CITY OF PORTLAND BUILDING PERMIT

Job ID: 2011-02-388-SF

RE: Review Comments for Single Family Site Plan

Project Name: A & M Partners
Project ID: 2011-02-388-SF
Project Address: 122 Sheridan Street **CBL:** 013 - J - 007-001

Drawing file: 1-28-2011 Sheridan Street Permit Set / Civil.PDF

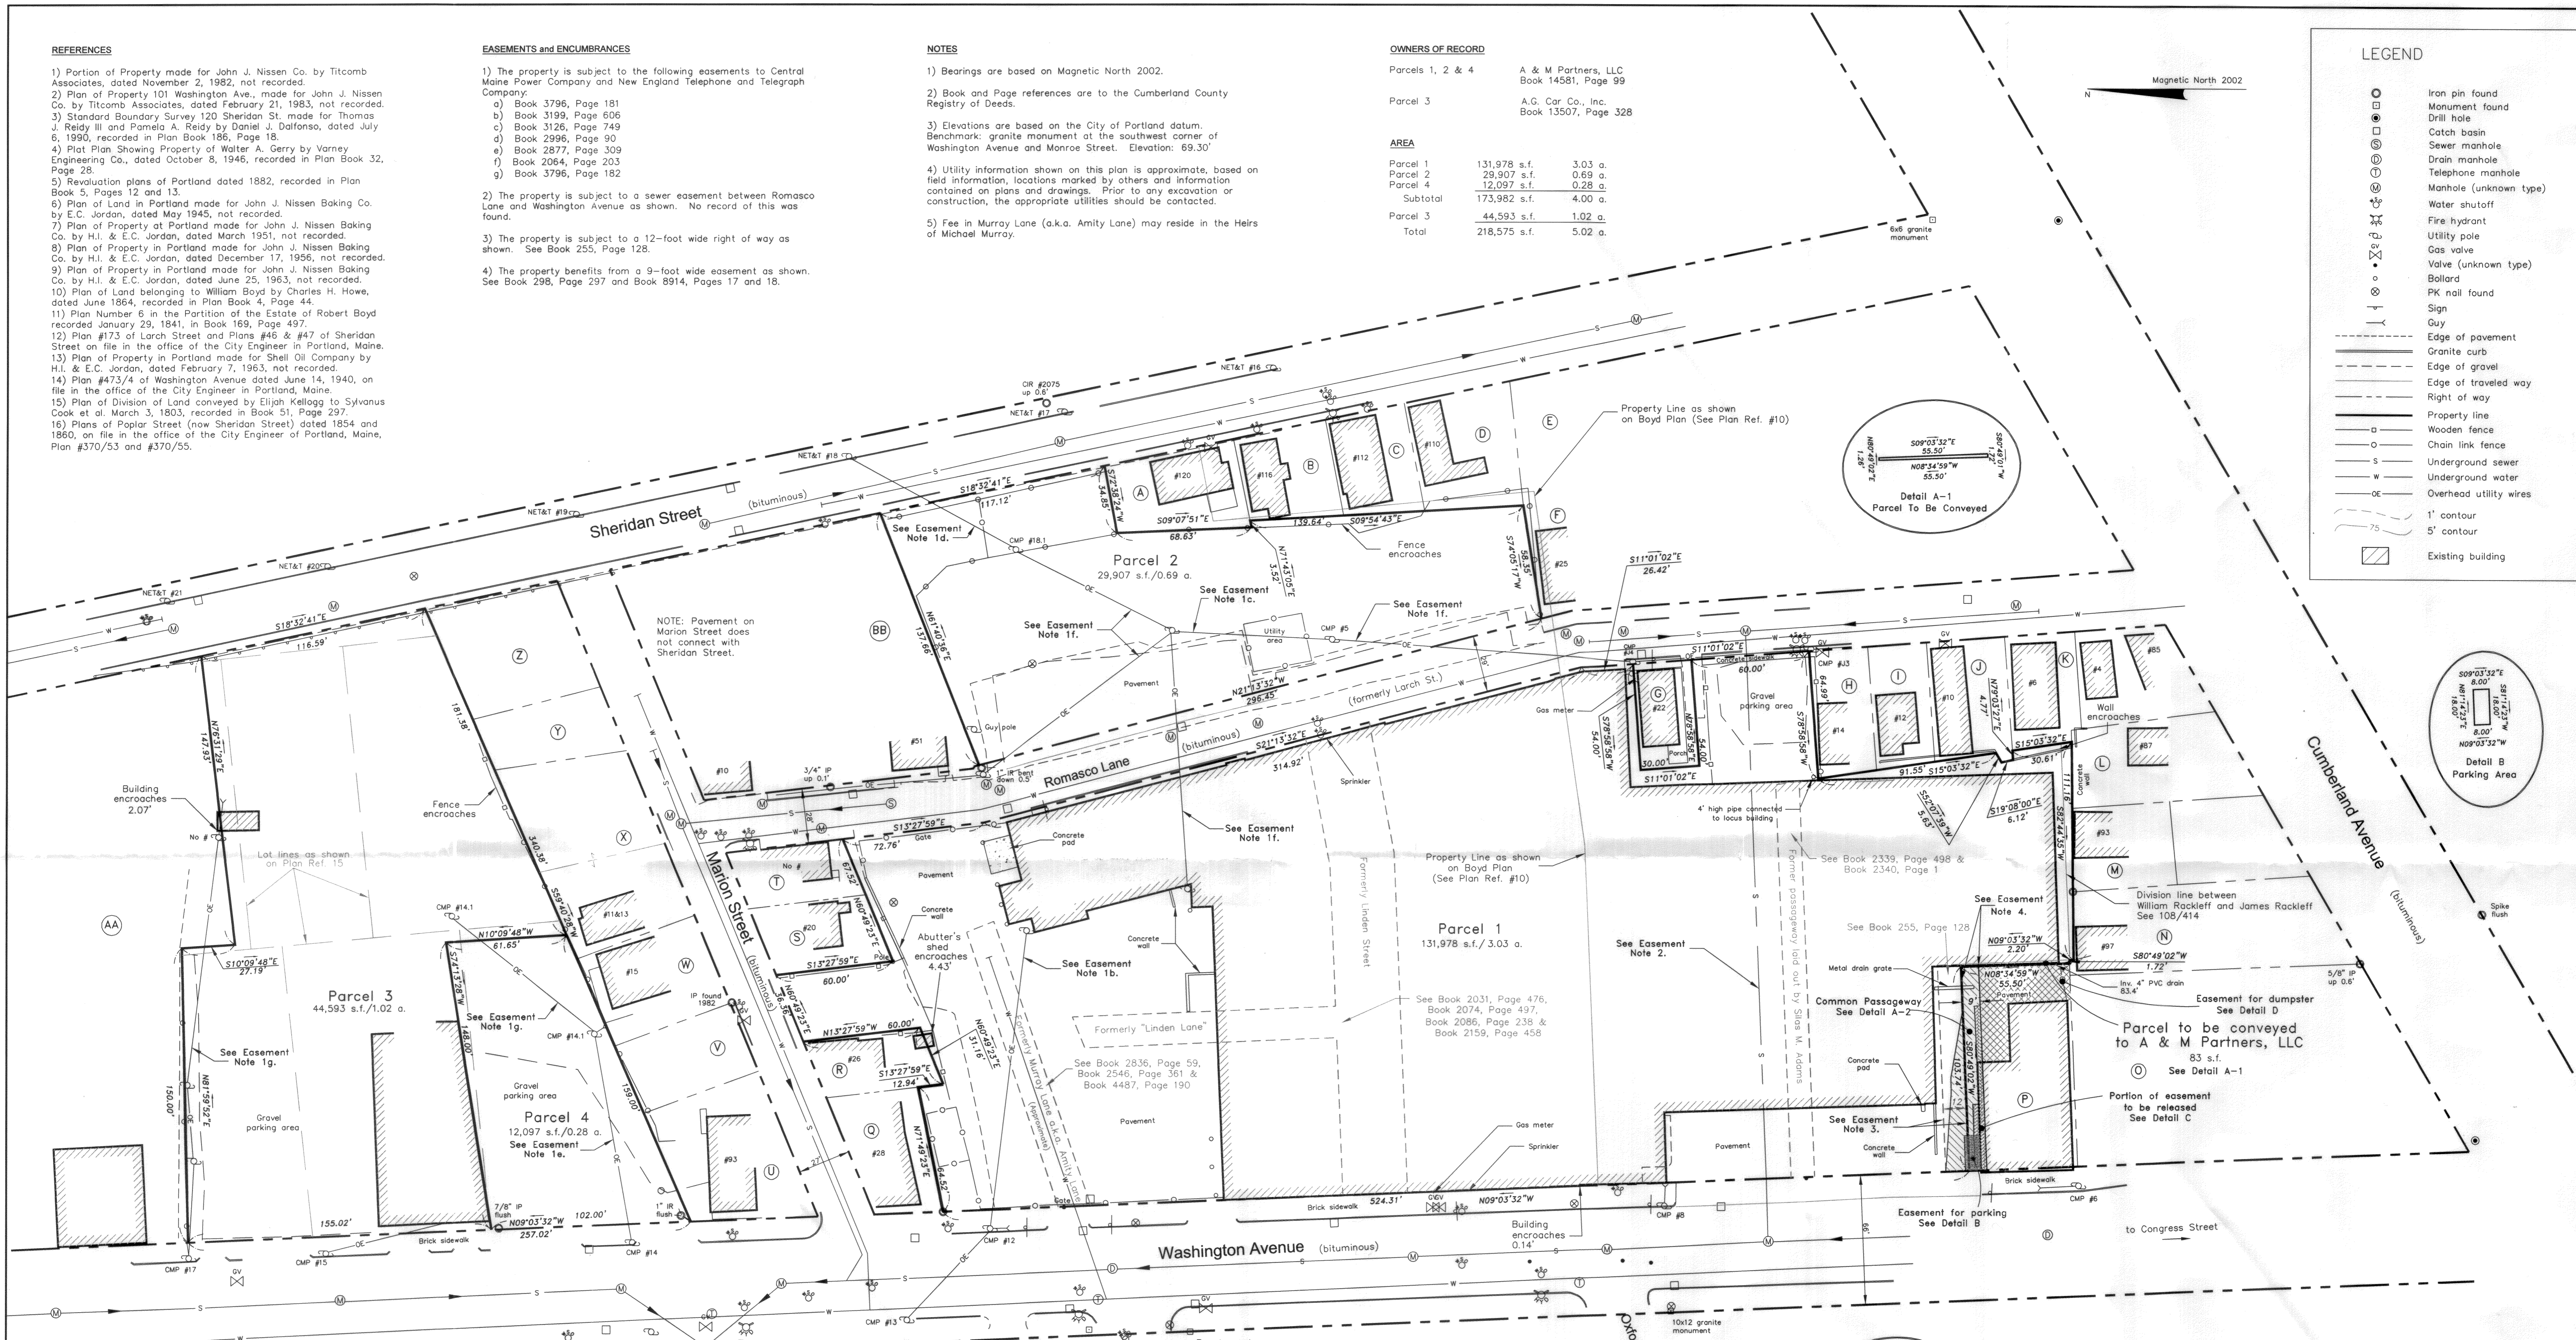
1. Please submit a revised survey to include the following information:
 - Please include a vicinity map on the survey,
 - Please add the flood zone information to the survey, ie. which zone the property is in based on the FEMA Flood Insurance Rate Map.

to submit a geotechnical assessment performed by a licensed professional engineer,

- Given the steepness of the slope, a double row of erosion control measures will be required. Please add this to the site plan,
- Please add the two required street trees, or show the trees that are to be preserved meeting the City's minimum arboricultural standards,
- Please show the locations of the drywells on the site plan. Also, please include a detail of the drywell construction.

- Please show the approximate locations of all structures within 50 feet of the property lines.
- Property corners. Where no property markers exist, the City of Portland requires that the property markers be installed and, in some instances that a licensed surveyor set and confirm proposed building locations on site prior to the issuance of a building permit.
- The survey needs to be signed and sealed by a professional land surveyor licensed to practice in the State of Maine.
- Please show the street status on the survey, ie., accepted, continued, discontinued, vacated, etc.
- Please add or confirm that the City's official vertical datum, NGVD 1929, was used for this survey.
- The survey needs to tie the property into the nearest accepted street line and the nearest monument or record survey data. Please show this information.

1. Please submit a revised site plan that shows the entire site on one sheet with proposed improvements at scale that includes the following information:

- Please identify the zoning district, setbacks, and dimensional requirements on the site plan.
 - Please include in square feet the amount of proposed paved area,

- Please show the ground floor area of the proposed building.
 - Please show the proposed finished floor elevation (FFE) or sill elevation on the site plan.

- Please show all proposed utility connections ie., water, sewer, electric, gas, etc., on the site plan. Be advised that the sewer connection cannot tie directly into a manhole, it must connect directly to the main,

- Please show proposed grading contours. If no grading of the site is proposed, please note it on the site plan.
 - Please show the total area, and limits of ground disturbance in square feet, on the site plan,

- Please show the driveway curb cut on the site plan. Be advised there must be a minimum 20 foot separation, measured at the property line, between the edge of the proposed driveway and any existing driveway. Also the proposed driveway must maintain a width of between 10 feet and 20 feet at the property line,

- Please show the location of the foundation/footing drain outlet,
 - Please include the soil type for the property. Due to the steepness of the site and the proposed location of the structure, you may be required
